DRAWN BY: O.E. WATTS	REVISIONS	OLIVER E. WATTS CONSULTING ENGINEER COLORADO SPRINGS	PROJECT 5310 & 5390 VESSEY ROAD L'S 21&22, CATHEDRAL PINES #2 EL PASO COUNTY	SHT. NAME <b>SITE PLAN</b>	SHT. NO. 1 OF 1
DATE: 3-1-18					
DWG. NO.: 18-5142-01					
SURVEYED BY: DEW, ESW, DJW, 3-23-18

# Markup Summary

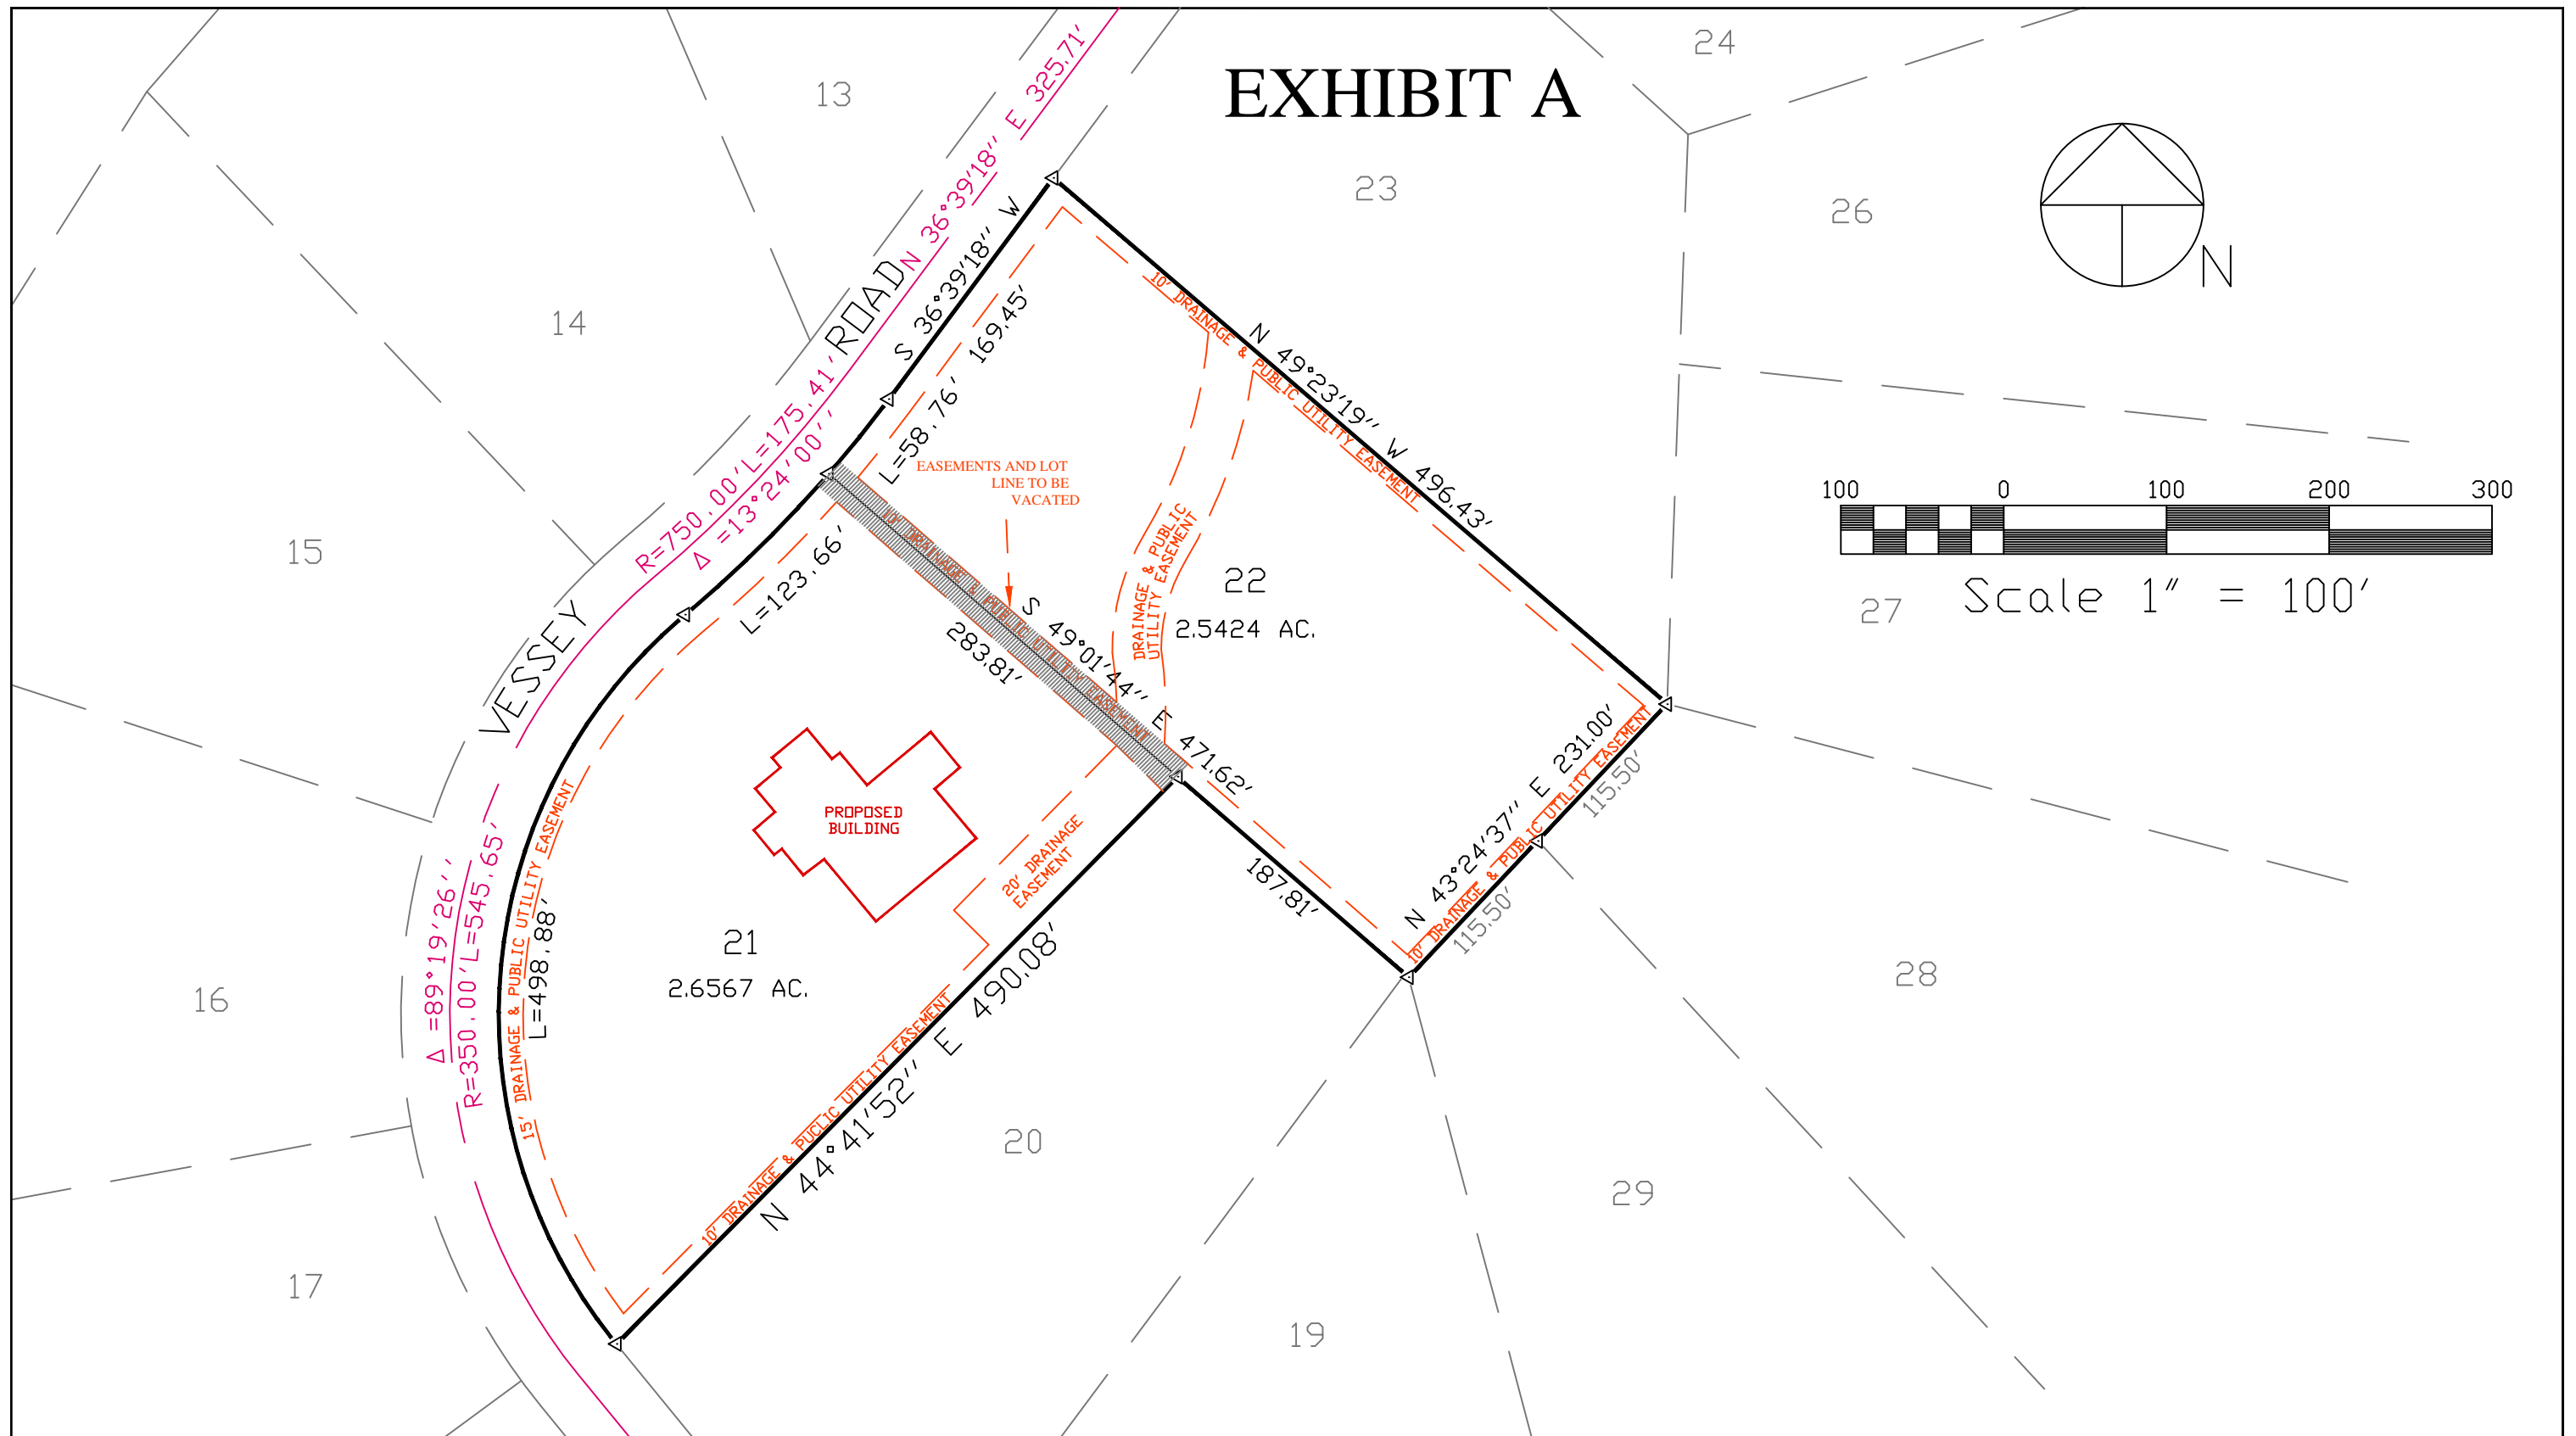
Show Easements
